Medworth Energy from Waste Combined Heat and Power Facility

PINS ref. EN010110
Document Reference Vol.18.2a
Revision: 1.0
Deadline: 8
August 2023

Applicant's comments on the Deadline 7 Submissions: Part 1 Statutory Parties

**Figure 10.1iv**  
**Cromwell Road/New Bridge Lane Signal Scheme - General arrangement**

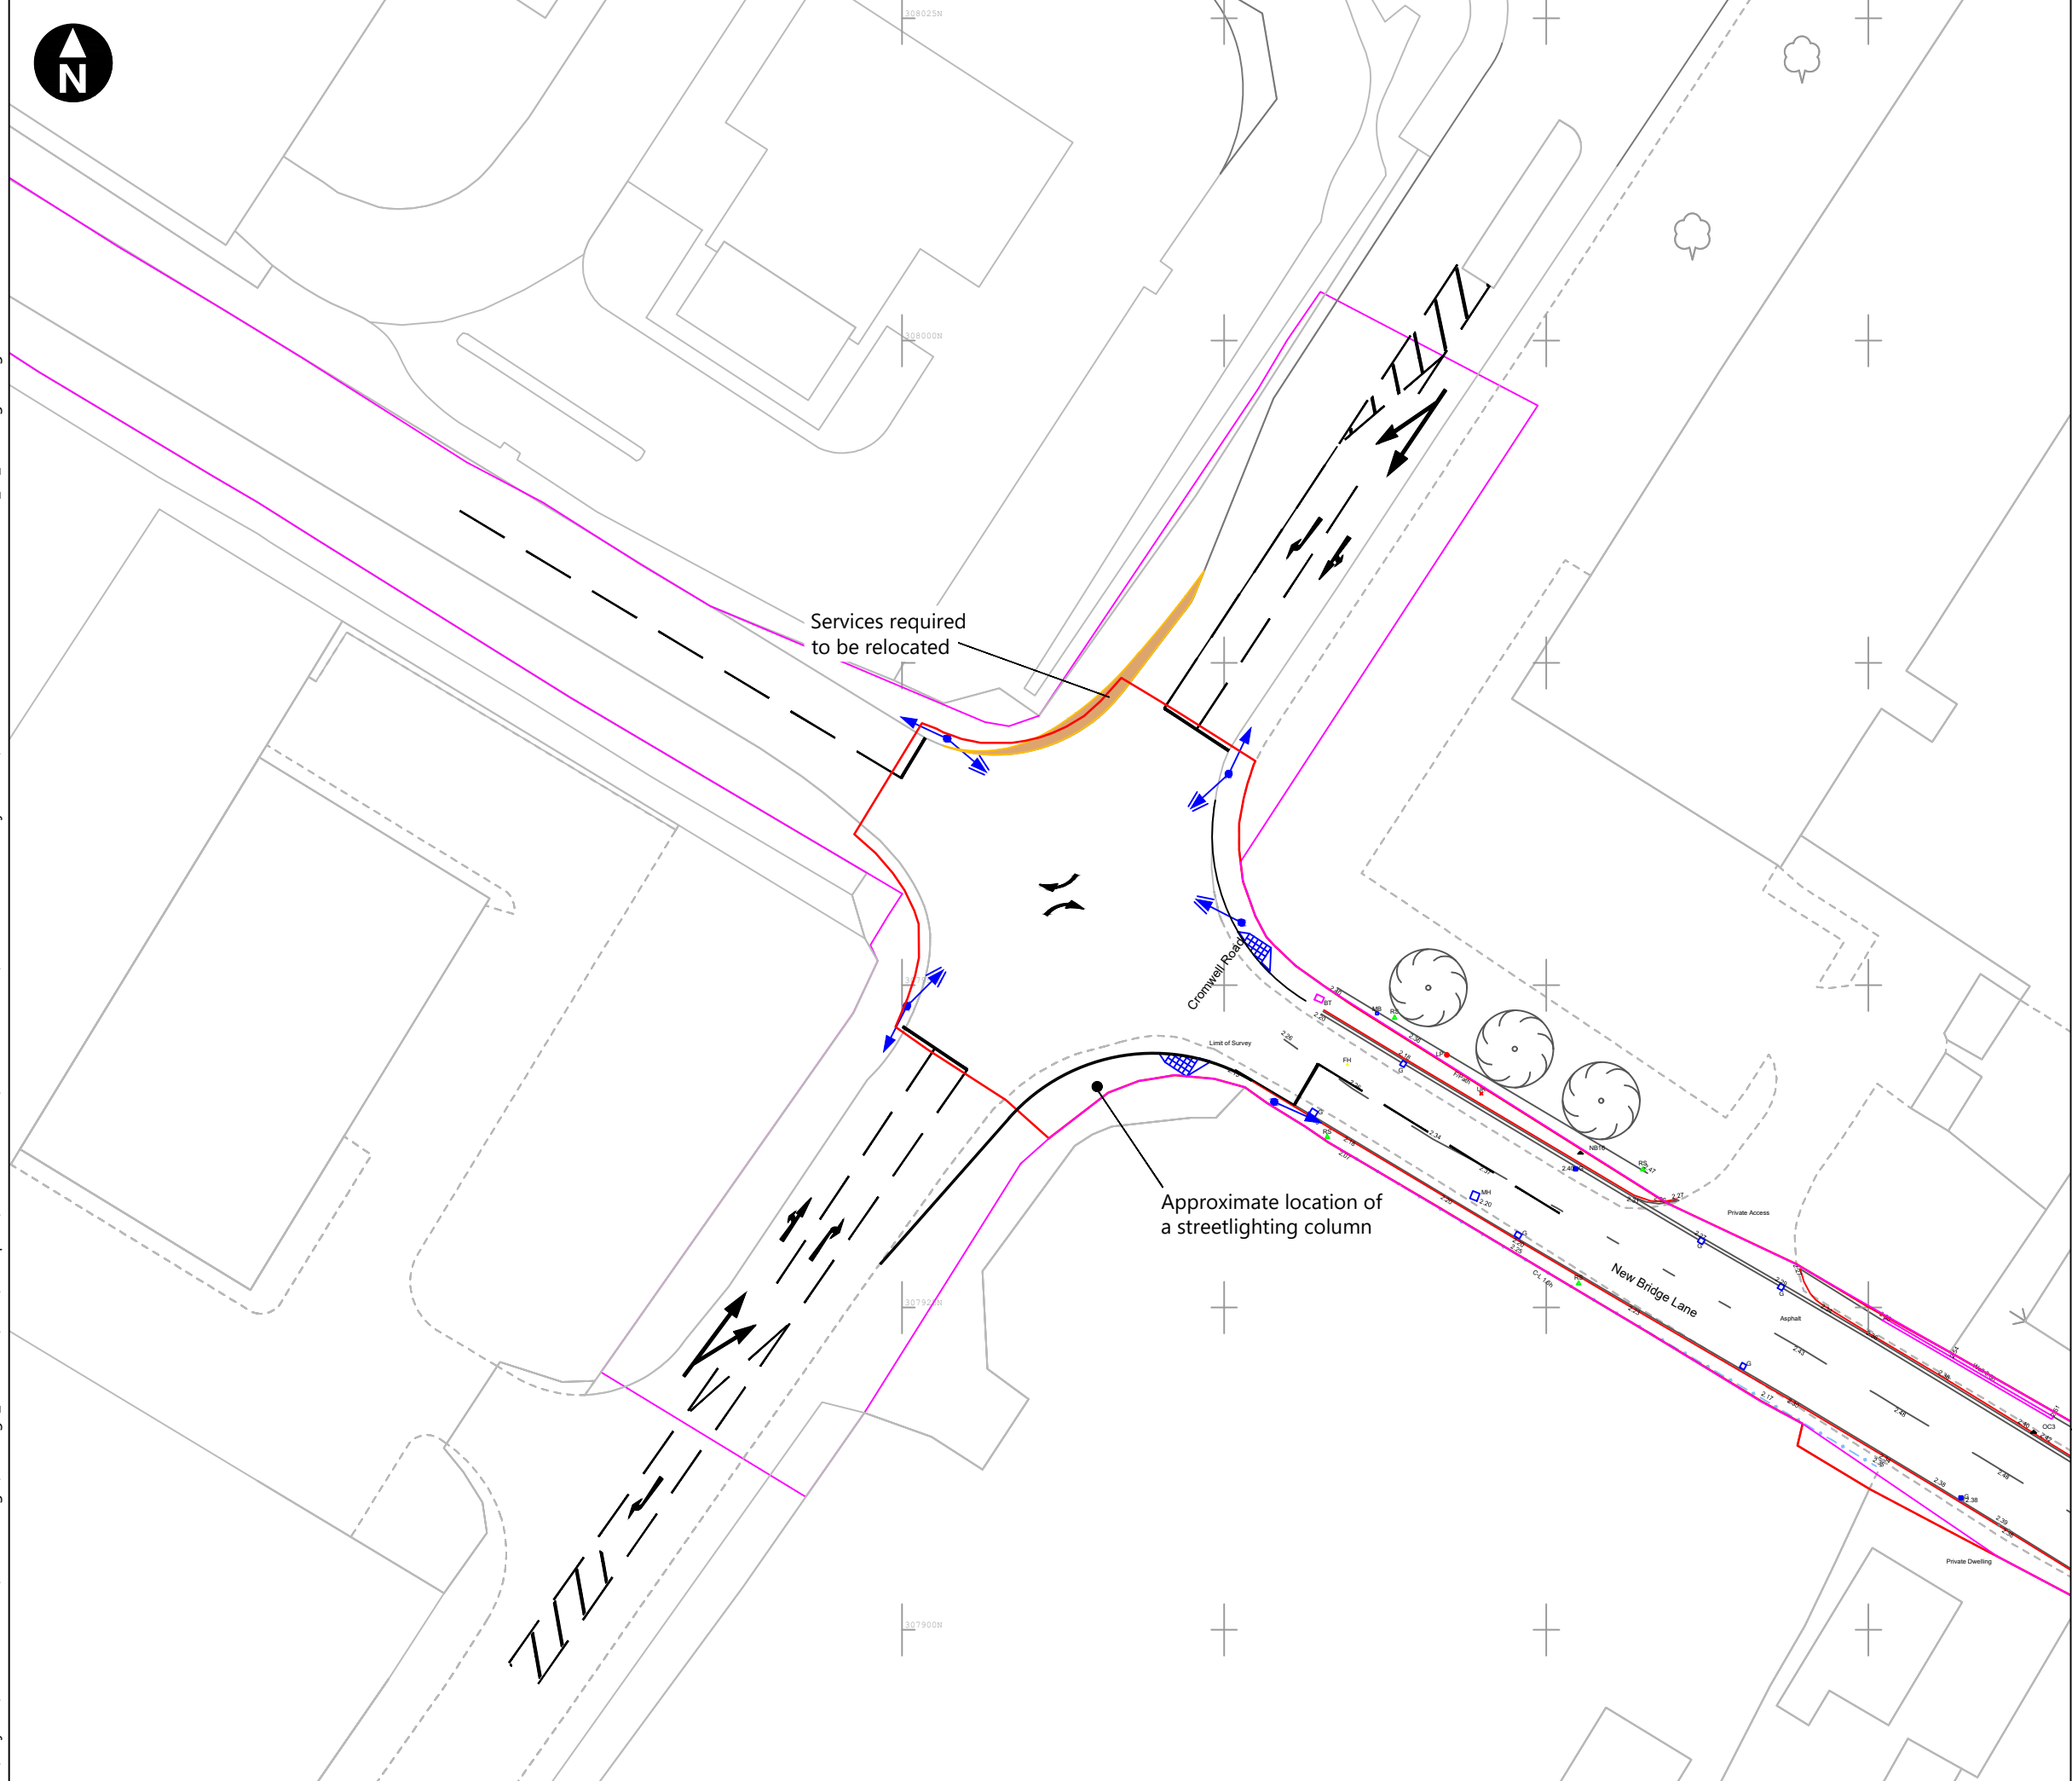
Volume 15.5 Applicant's Comments on the Responses to the ExA's Written Questions (ExQ2) [REP6-027]		
<i>General and Cross-Topic Questions</i>		
Signalisation of Cromwell Road / New Bridge Lane Junction	<p>The Applicant has noted the meeting of 6 July 2023 that took place with CCC in relation to the re-design of the Cromwell Road/New Bridge Lane junction. CCC acknowledges that additional modelling information</p>	<p>Following the meeting on 06 July 2023, the additional signalisation modelling information was issued to CCC on 24 July 2023. The Applicant met CCC on 02 August 2023 to review the modelling analysis. CCC confirmed (see ES Chapter 6 Traffic and Transport Appendix 6B Transport Assessment Addendum paragraph</p>

Topic/Para	CCC/FDC Representation	Applicant Comment
GCT.2.3	<p>with regard to the signals will be provided by the Applicant.</p> <p>However, the Applicant has not noted a key concern raised by CCC at that meeting – that the powers of acquisition to be included in the DCO, in relation to land currently owned by Tesco, may not be sufficient to ensure that all new infrastructure at the junction can be adopted by CCC as highway maintainable at public expense.</p> <p>CCC understands that the Applicant is engaging its solicitors on this matter, but has yet to receive any further information or proposal from the Applicant. CCC will continue to engage constructively with the Applicant in pursuit of an acceptable outcome on this issue.</p>	<p>5.1.4 (Volume 13.3) [REP-025], the model was robust, and the construction stage detailed design process would address any remaining matters. In summary, this matter is agreed and therefore closed for the Examination.</p> <p>As set out in Section 2.4 of the Change Application Report [AS-028] the dDCO includes two powers for the Applicant to carry out the highway works. These are (a) the use of Article 11 which enables works to be carried out to both public highways and streets listed in Schedule 4, which includes this part of Cromwell Road/New Bridge Lane, and (b) the use of the temporary possession powers in Article 32 and Article 33. Therefore, the Applicant is of the position that the powers in the DCO are sufficient to be able to carry out works in the unlikely event that Tesco does not consent to the works.</p> <p>Further details are set out in the Applicant's Position Statement on Access Improvements (Volume 18.7) submitted at Deadline 8, including an explanation of the new article 48 in the draft DCO (also submitted at Deadline 8). The Applicant considers that it has adequately addressed CCC's concerns as reflected in the Statement of Common Ground between the Applicant and CCC submitted at Deadline 8.</p>

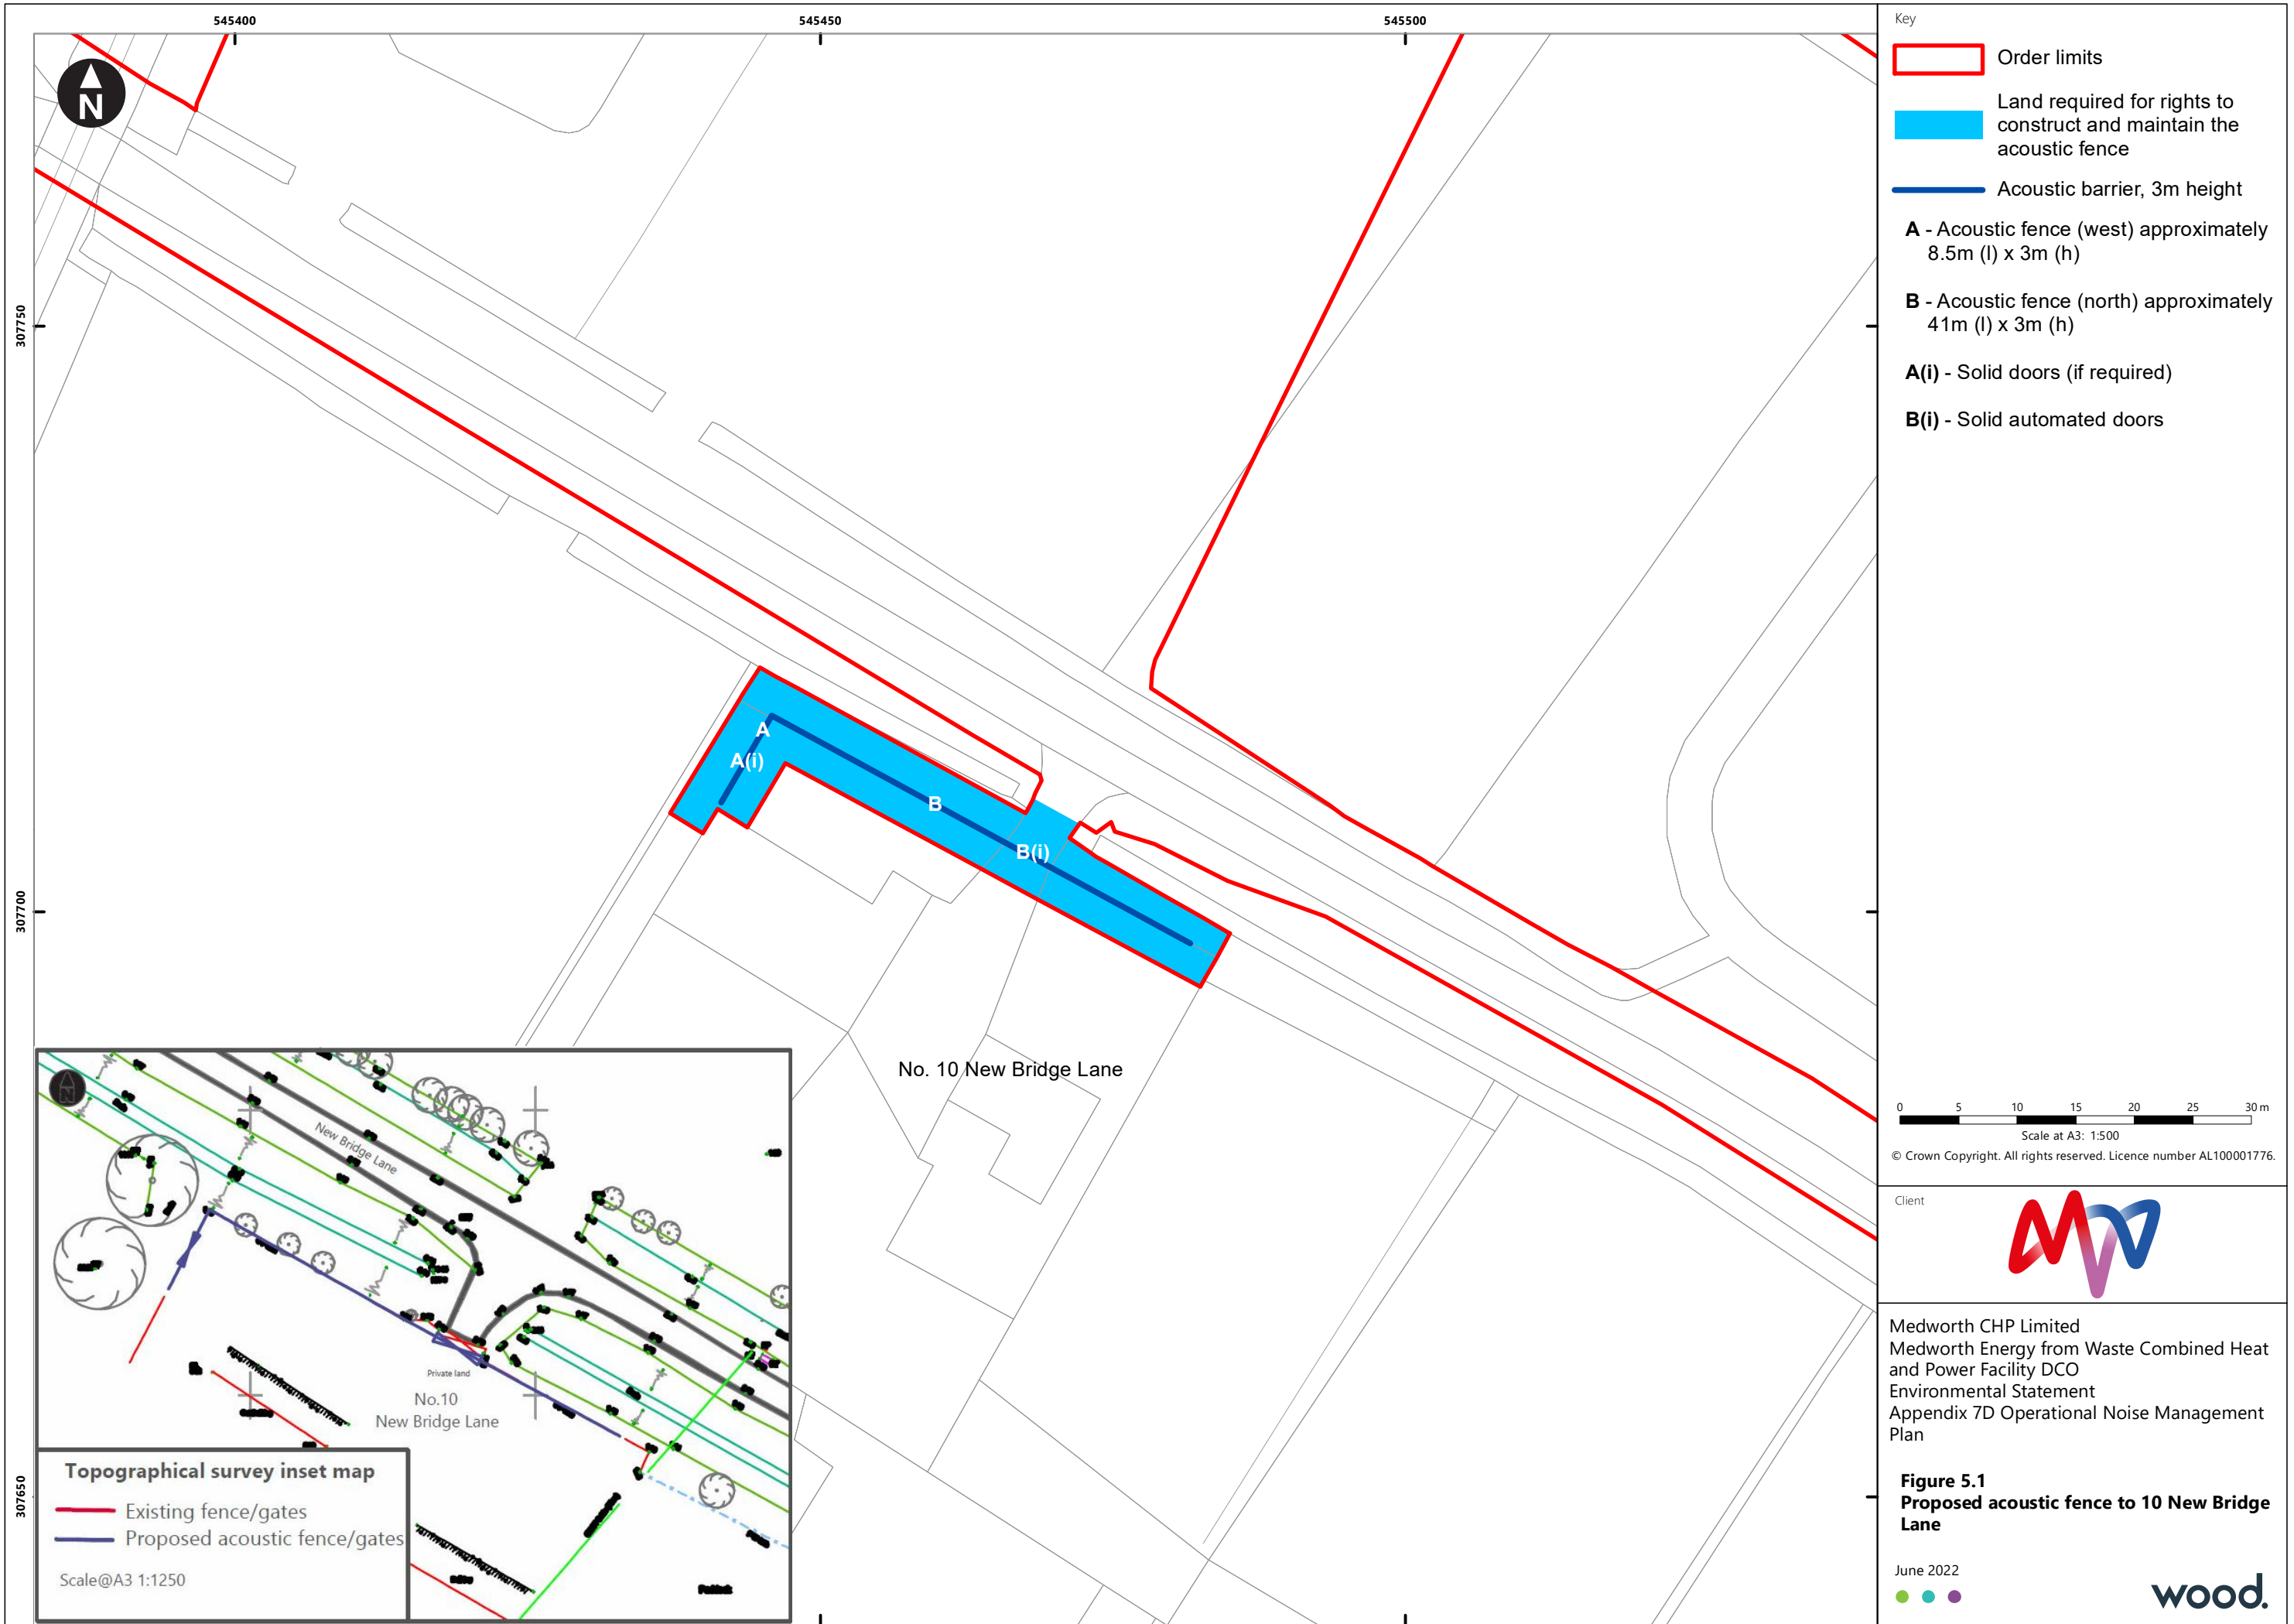
Topic/Para	CCC/FDC Representation	Applicant Comment
	<p>development will not be distinctive and in the case of HGV movements noise would be intermittent. Where characteristics of noise are predicted to be experienced, a penalty rating of +3 to +9dB may be applied to the rating level.</p> <p>Without a penalty rating, the outcome results in a 3dB increase in noise levels after the installation of the barrier. The calculation then added a noise correction due to the current typical background noises for this location being described to currently include industrial type noise sources. This determined that the noise change would be perceived at an increase of +2dB due to the introduced noises being in keeping with the local area.</p> <p>At this point of the application process, the noise barrier design has not been provided. Therefore, there has been no consideration if the introduction of a noise barrier itself will change the current noise exposure 10 New Bridge Lane experiences from the A47. The installation of the noise barrier may result in an increase of road traffic noise from the A47 experienced at 10 New Bridge Lane due to a reflective surface resulting in noise build up and impacting on areas of 10 New Bridge Lane which were previously screened from noise sources such as the rear of the property.</p> <p>With the assumptions made regarding the characteristics of the noise and the design brief of the acoustic barrier yet to be provided within the planning process, the Councils do not have sufficient information to justify that the noise will be mitigated to a level where it will no longer be significant to 10 New Bridge Lane.</p>	<p><i>“4.3 Whilst the Council is still waiting for some minor additional data / clarifications to be shared, the outcome of the assessment and conclusions drawn in this documentation (including Annexes B, C, E and F) are accepted – and Officers are satisfied that this work has been undertaken by suitably competent personnel, in accordance with all relevant legislation and technical guidance.”</i></p> <p>The acoustic fence specification has been designed based on the outputs from the noise assessment supporting the DCO Application (Appendix 7D Outline Operational Noise Management Plan Volume 6.4) [REP3-015]). That assessment includes contributions from HGV's manoeuvring within the EfW CHP Facility Site, but also includes additional contributions from HGV's operating on New Bridge Lane. Furthermore, the Outline Operational Noise Management Plan Rev 4, Appendix 7D, (Volume 6.4) [REP5-014], specifically developed for the DCO application, which addresses the impacts from HGV's on New Bridge Lane, also includes the acoustic fence as a mitigation measure. Conditions to adhere to this management plan, whilst supporting ongoing access to the acoustic fence and the requirement to construct and maintain it throughout the lifetime of the Proposed Development, would be secured by DCO Requirements.</p> <p>The critical aspects of the design of the acoustic fence are the height and length of the fence. These aspects are defined in the figure within Section 5 of the Outline Operational Noise Management Plan [REP5-014]. Other details of the fence will be confirmed at the detailed design stage. The acoustic barrier is subject to design and procurement, but early discussion with one supplier has identified an acoustic barrier meeting a surface density of 26kg/m², and in all cases, a performance greater than 20kg/m² would be sought. The moving gate will be clad in the same material and the threshold gap will be designed to minimise flanking.</p>

Topic/Para	CCC/FDC Representation	Applicant Comment
		<p>It is most unlikely that the fence would cause any appreciable increase in road noise from the road traffic on the A47 due to reflected sound. There are a number of structures present at 10 New Bridge Lane, including the dwelling itself, which provides significant screening from noise from the south that would reduce reflected sound from the fence. Additionally, during the baseline surveys, industrial and commercial sound was found to be dominant at 10 New Bridge Lane with road noise also a significant contributor. On this basis, it is most unlikely that any reflected road noise would cause any material change to the ambient noise levels at 10 New Bridge Lane.</p> <p>Based on the above, the Applicant's position remains that the acoustic fence provides sufficient mitigation and that there will be no significant effects to 10 New Bridge Lane.</p> <p>To assist CCC/FDC's understanding on how the regulatory frameworks of the DCO and Environmental Permit would operate, further information for the design and maintenance of the acoustic barrier was issued on 19 July 2023, see Appendix A (Technical Note: Regulation of Noise Controls (acoustic fence), (July 2023)).</p>
